DOC17/133932; EF15/16586

State Significant Development (SSD 7332) - Proposed Eagleton Quarry – Eagleton Rock Syndicate Pty Ltd - Environment Protection Authority (EPA) Comments and Recommended Conditions of Approval

EPA comments - Proposed Eagleton Quarry (SSD 7332) Environmental Impact Statement (EIS) January 2017

Dam 1 28.0ML
Water quality and detention.

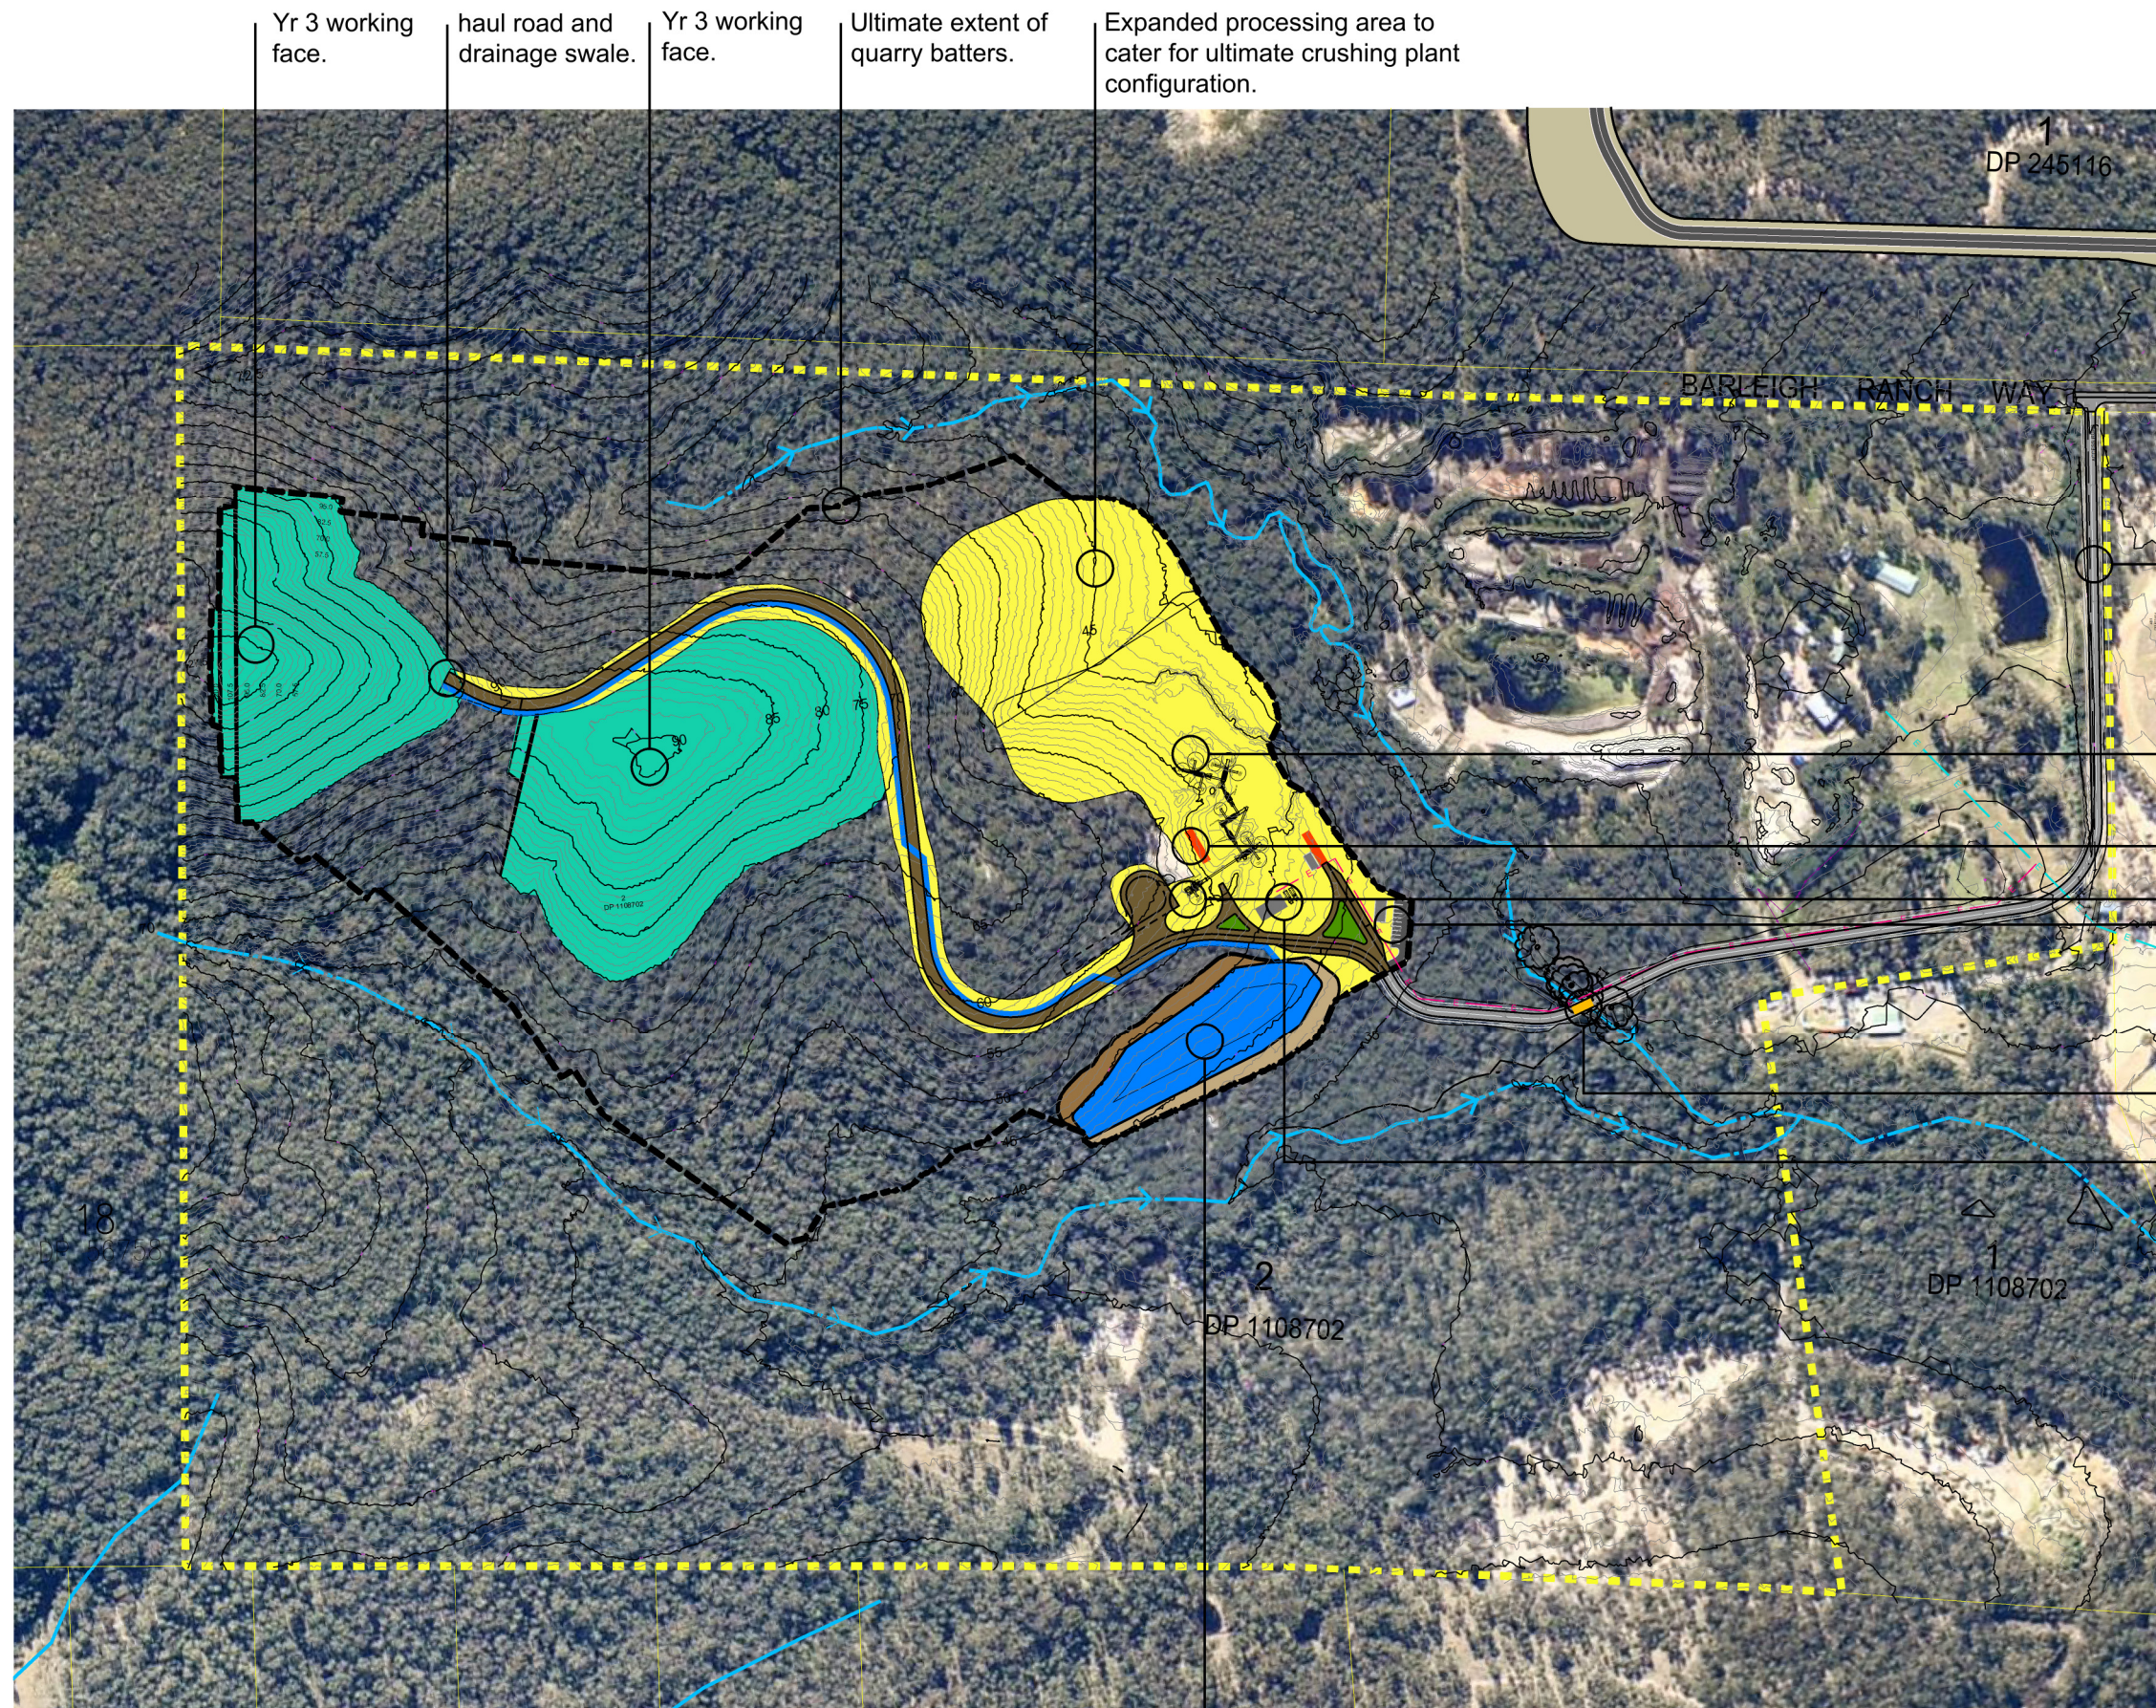
approximately 259 mm). Captured water will be re-used on site in processing and dust suppression. Two dams providing a total of 57ML storage (i.e. Dam 1 = 28ML and Dam 2 = 29ML) are to be installed and operated to capture dirty water.

Adequate management of the water management system is crucial to prevent discharges below the system design criteria. The EPA recommends adequate capacity be maintained in the dams to capture the design rainfall events and the installation of a level or volume indicator on the dams.

An emergency overflow from Dam 1 into Seven Mile Creek is to be installed for rainfall in excess of the water management design criteria. Installation of the dams is to be staged with Dam 1 installed prior to construction activities and Dam 2 constructed at approximately Year 6 when the operational area footprint deems it necessary. The EPA has proposed conditions requiring water quality and volume monitoring daily during any discharge.

- 21) The drainage from all areas at the premises which will liberate suspended solids when stormwater runs over these areas must be diverted into adequately sized sedimentation basins.
- 22) The sedimentation basins, identified as Dam1 and Dam 2 in the EIS must be maintained to ensure adequate capacity to capture and store runoff from the design rainfall event criteria.

- 24) A level indicator is to be installed and operated continuously in the sedimentation basins.
- 25) Stormwater management measures must be prepared and implemented to mitigate the impacts of stormwater run-off from and within the premises in a manner that is consistent with the Stormwater Management Plan for the catchment. Where a Stormwater Management Plan has not yet been prepared the measures should be consistent with the guidance contained in Managing Urban Stormwater: Soils and Construction: Volume 2C Unsealed Roads and Volume 2E Mines and Quarries (DECCW 2008).

Figure 12: Proposed noise barrier locations, initial configuration

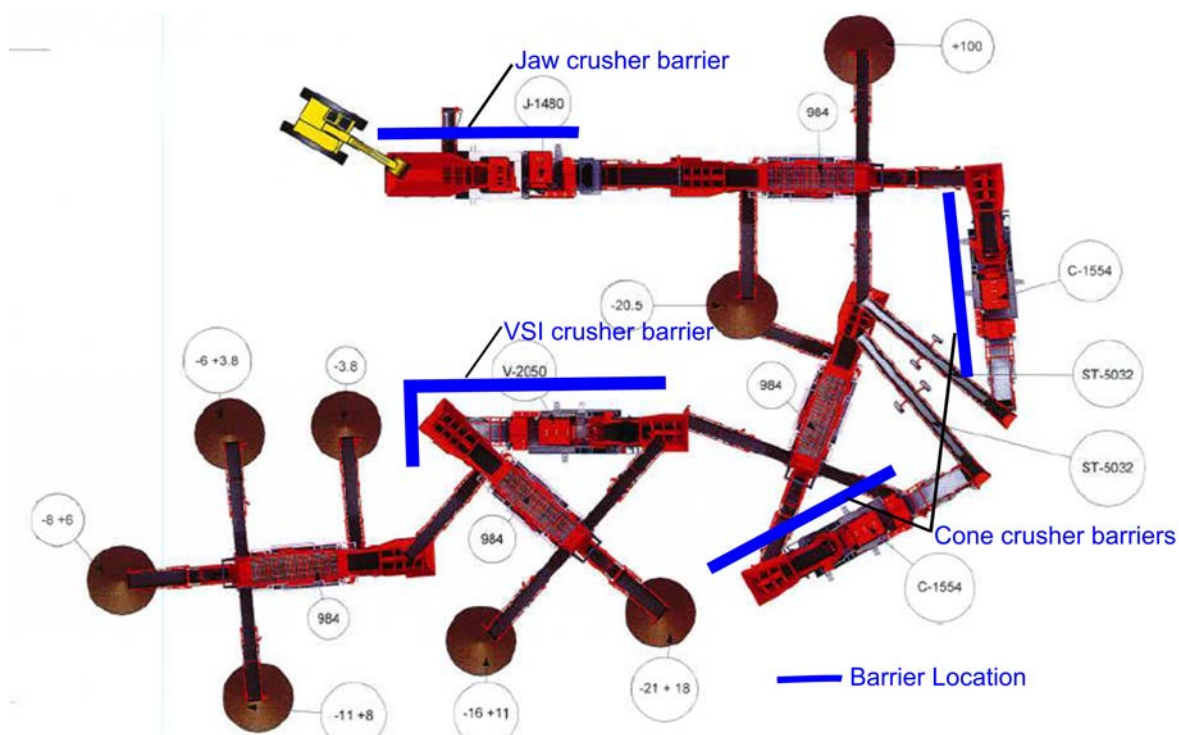
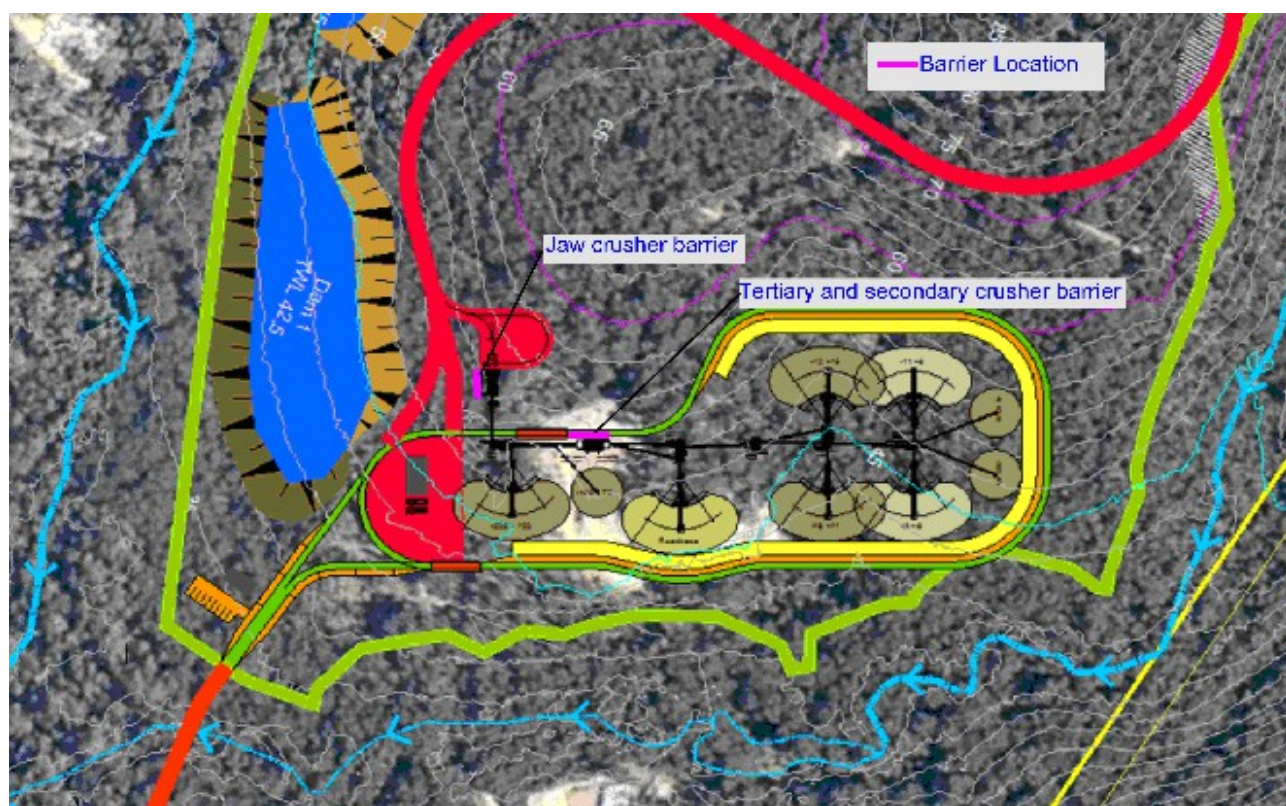
The noise limits proposed by the EPA are based on the proponent's noise modelling, which assumed all feasible and reasonable noise mitigation measures are implemented, including noise barriers. The proponent will need to design and build the quarry to include the feasible and reasonable noise mitigation measures recommended in the noise impact assessment (NIA) to ensure compliance with the proposed noise limits.

- 39) All noise mitigation measures identified in the Noise Impact Assessment for Eagleton Rock Syndicate Pty Ltd – Eagleton Quarry (Report Reference: 15396_R01_Revision C) by Global Acoustics Pty Ltd, dated 28 January 2017 and used to determine noise impacts from the premises must be installed prior to the commencement of crushing and processing activities.
- 40) Noise generated at the premises must not exceed the noise limits in the table below. The locations referred to are in Figure 21 – Reception Locations on Page 63 - Noise Impact Assessment for Eagleton Rock Syndicate Pty Ltd – Eagleton Quarry (Report Reference : 15396_R01_Revision C) by Global Acoustics Pty Ltd, dated 28 January 2017.
